Application no: 21/03889/DISC

Location: Land Adj To Promised Land Farm, Wendlebury Road, Chesterton

Objection to discharge Condition 48 (Framework Travel Plan) of 19/01740/HYBRID - Further information is required before the document meets OCC criteria.

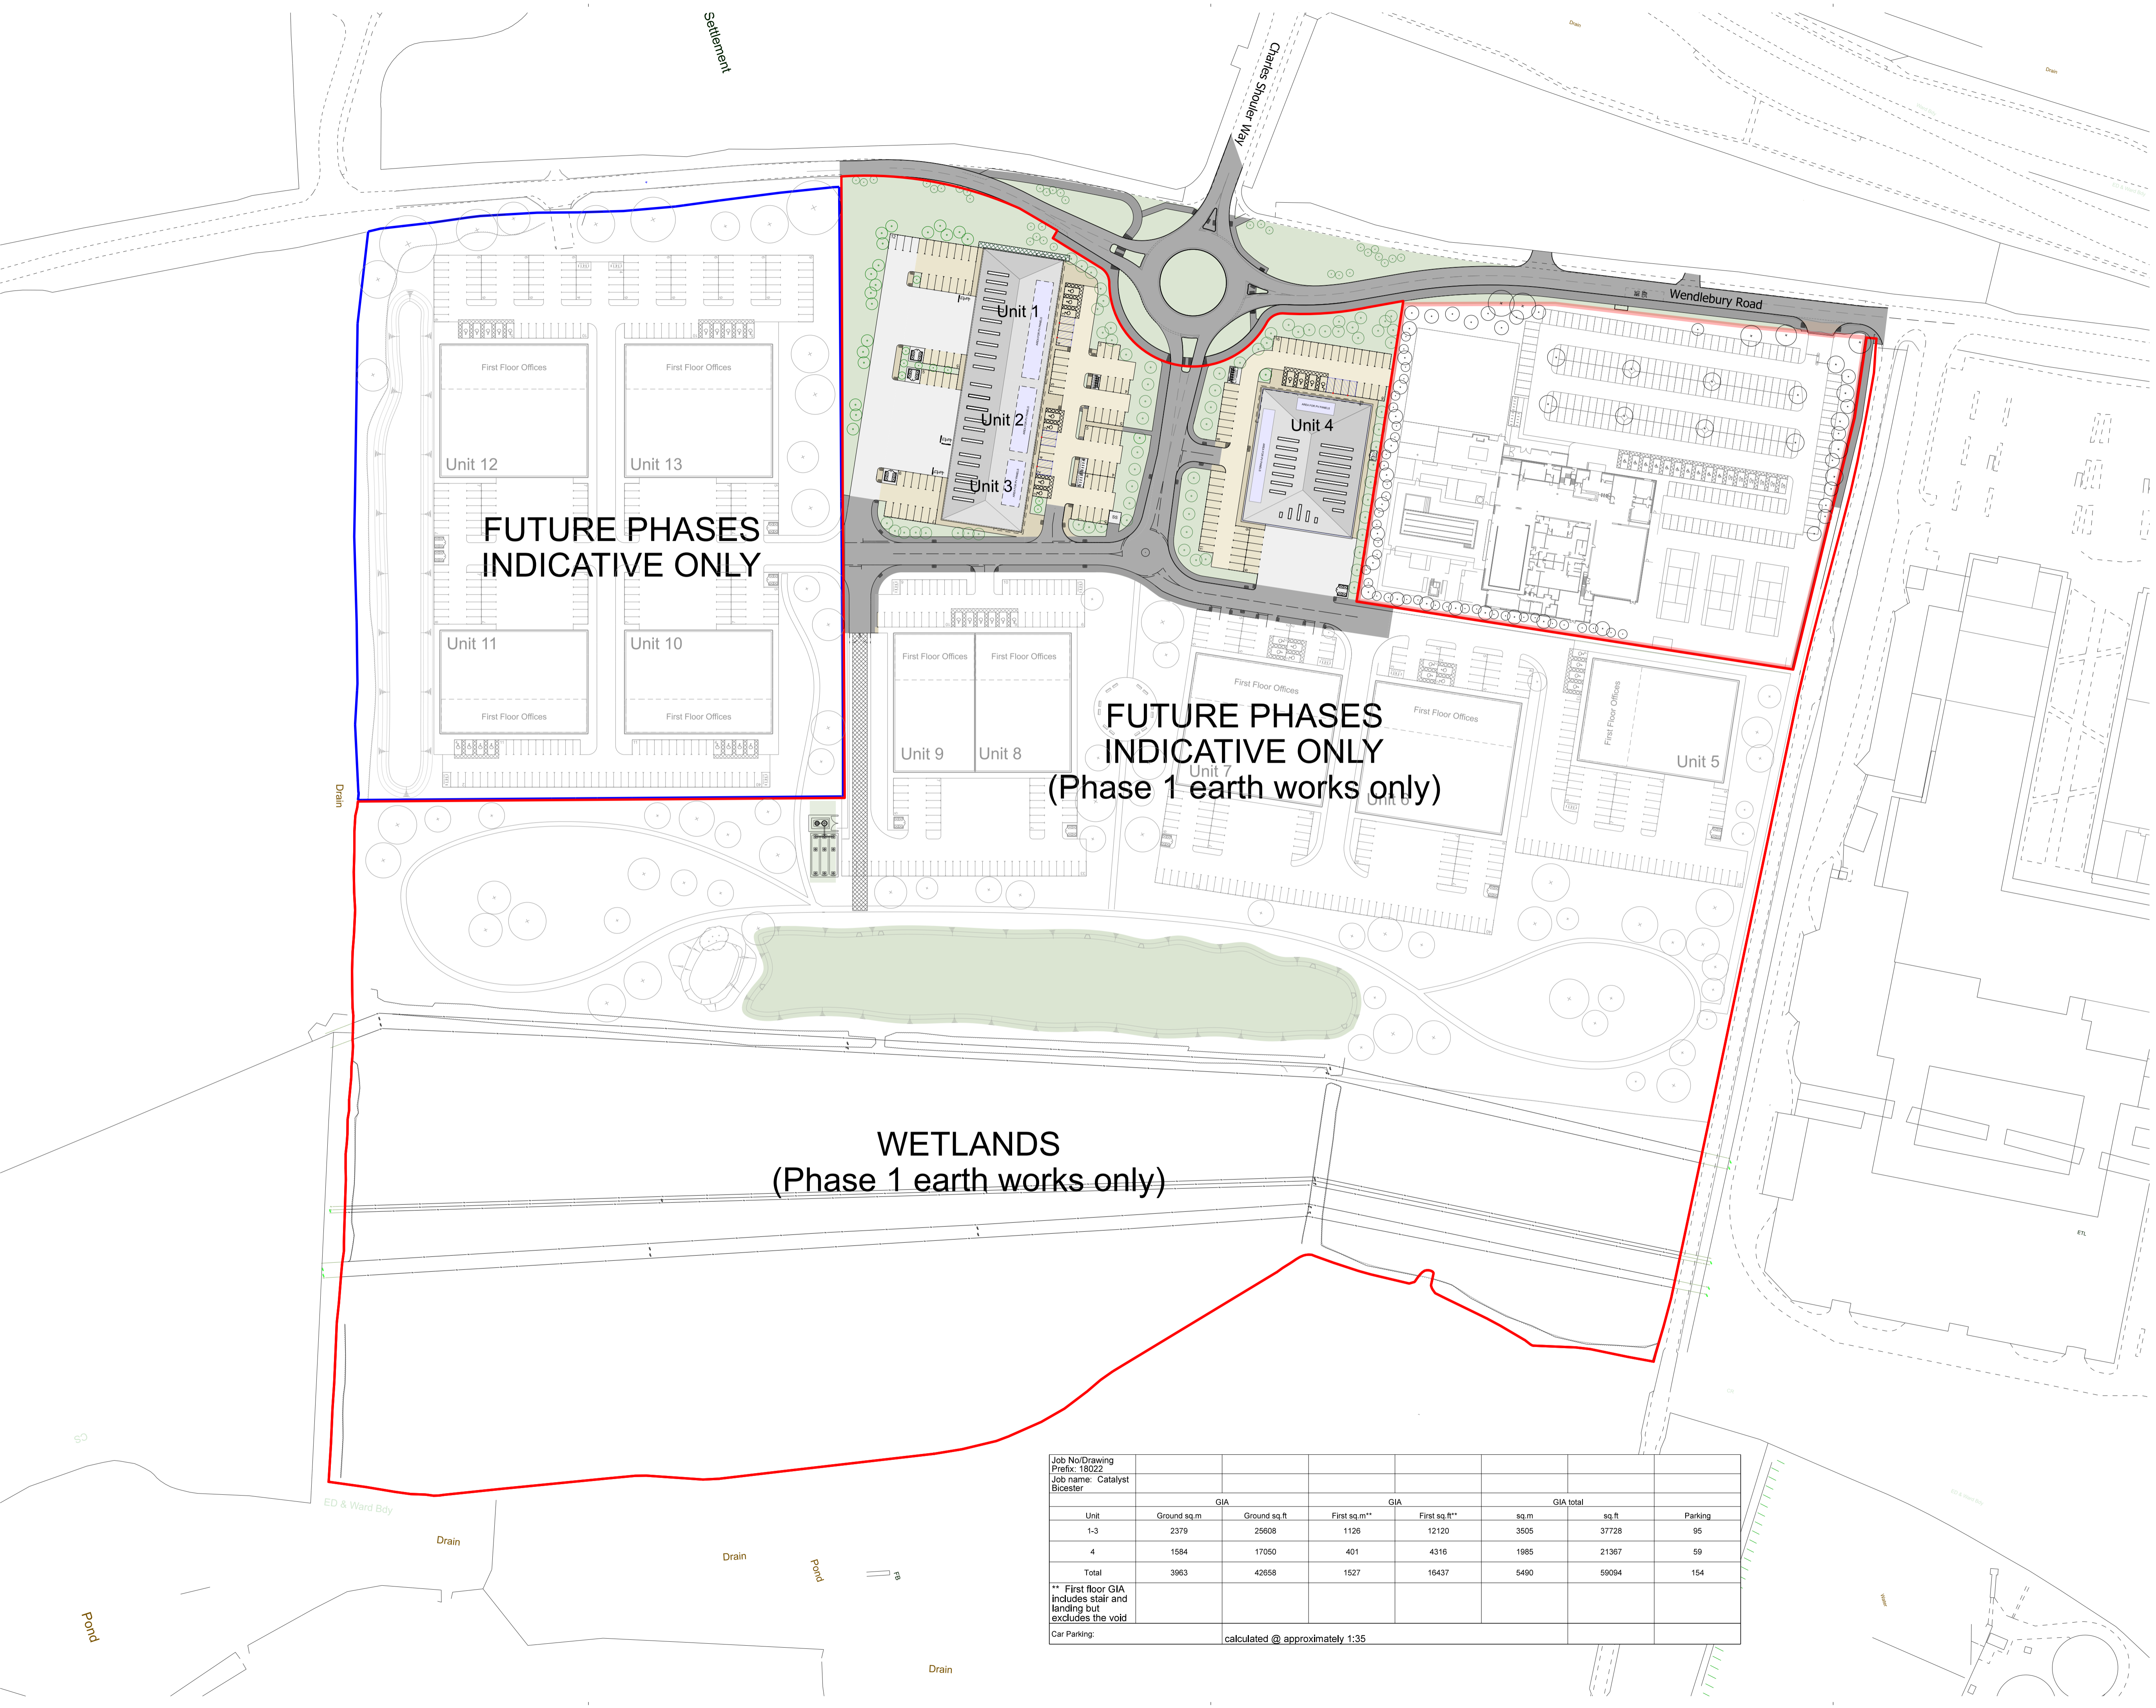
- Further information is required about the amount, type and location of the cycle parking.
- Details of the number of car parking spaces should also be provided.

- How many EV charging points will be provided across the site?
- What other facilities are to be provided onsite? E.g. lighting, car park barriers, covered walkways etc?
